Planning Application No: 3/2022/0623

Proposal: Proposed conversion of former stud farm stables to form part of residential dwelling and extensions to existing property.

Location: Woodfold Park Stud, Woodfold Park, Mellor BB2 7QA

proposed east wing plan

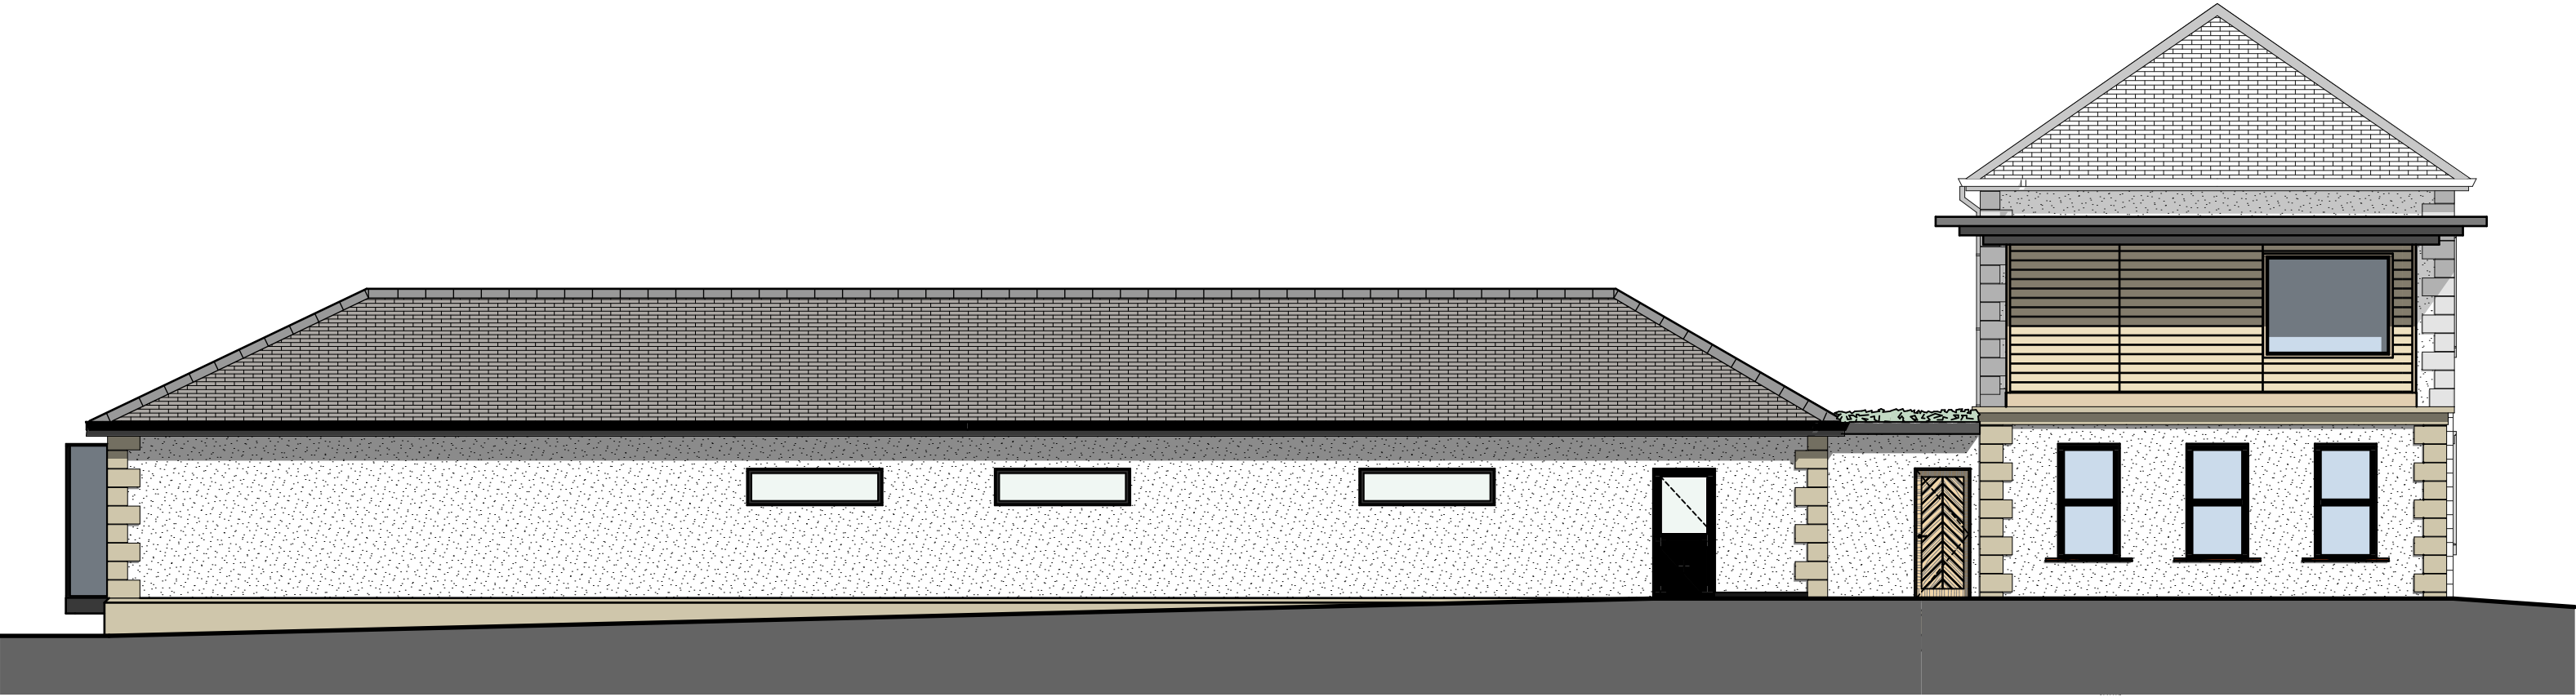
The double garage on the East of the site will be retained, providing two parking spaces and secure, covered cycle storage, plus an electric vehicle charging point can be provided, which would improve the site's sustainability.

Three parking spaces should be provided for the main dwelling, with one space to be provided for the one-bed annex on the East of the site. There is adequate space within the curtilage to provide these parking spaces, in addition to those within the garage.

proposed west wing plan

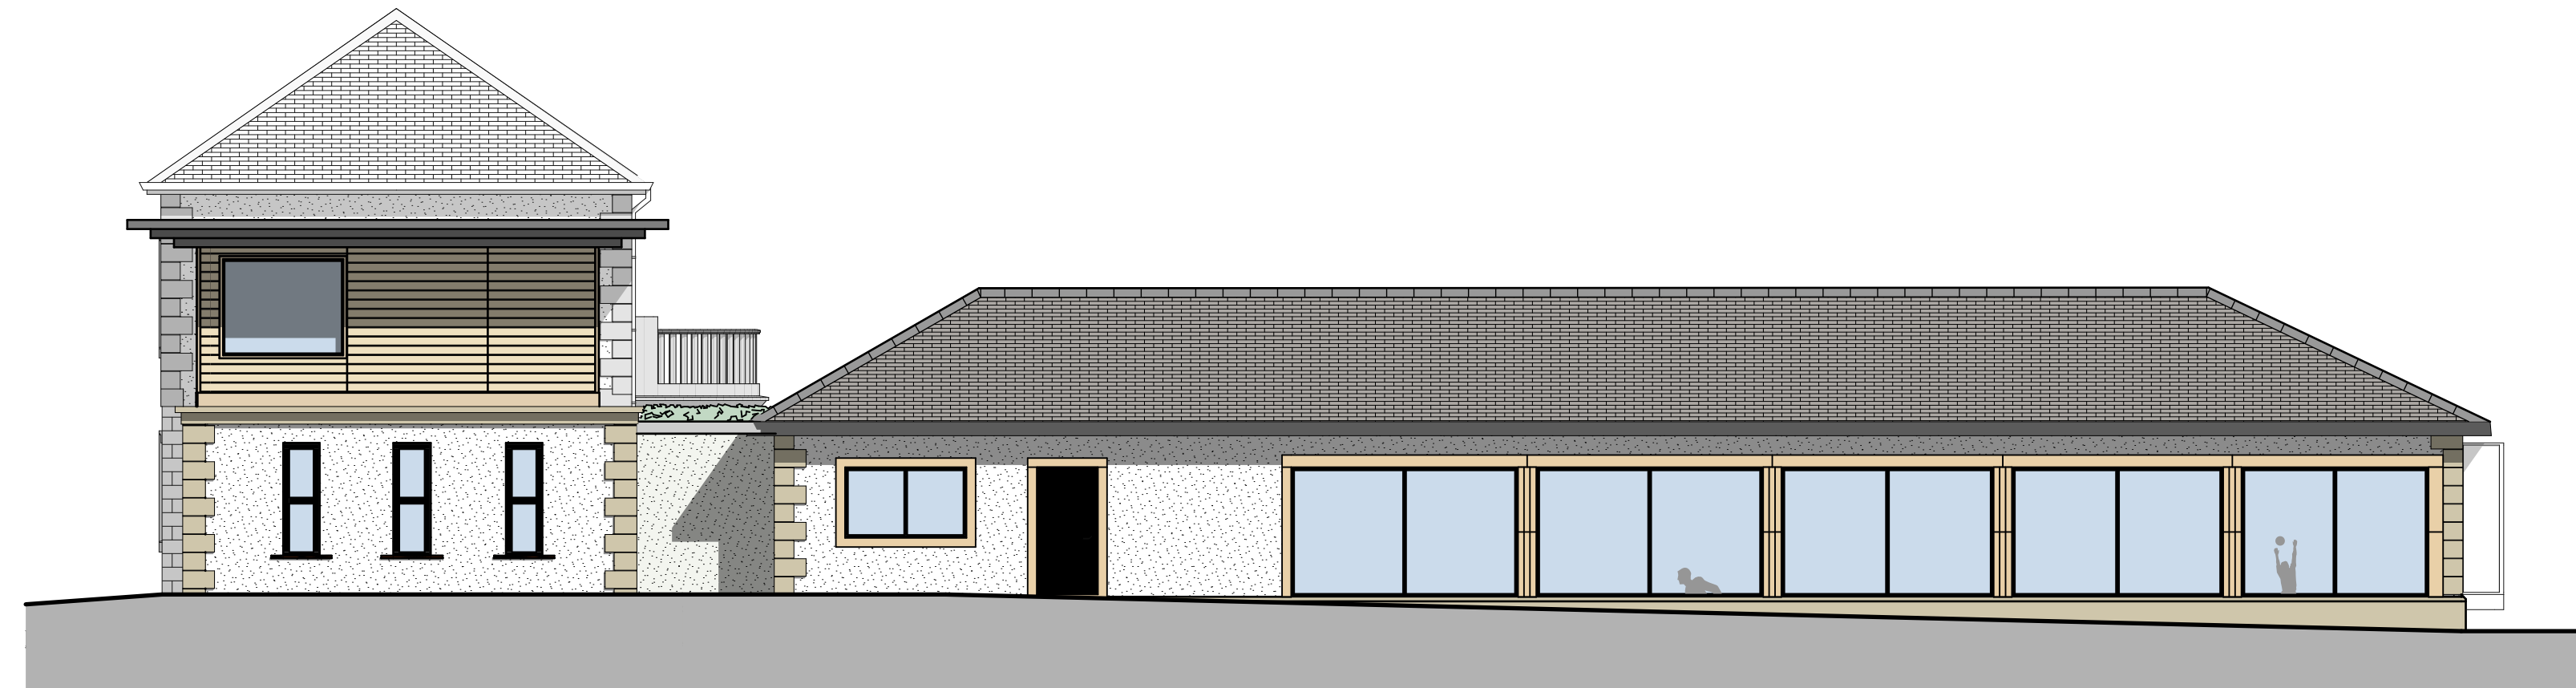
The garage on the West of the site would be lost to the conversion. However, as it is sub-standard in size to count as car parking its loss would not reduce the overall parking provision within the site.
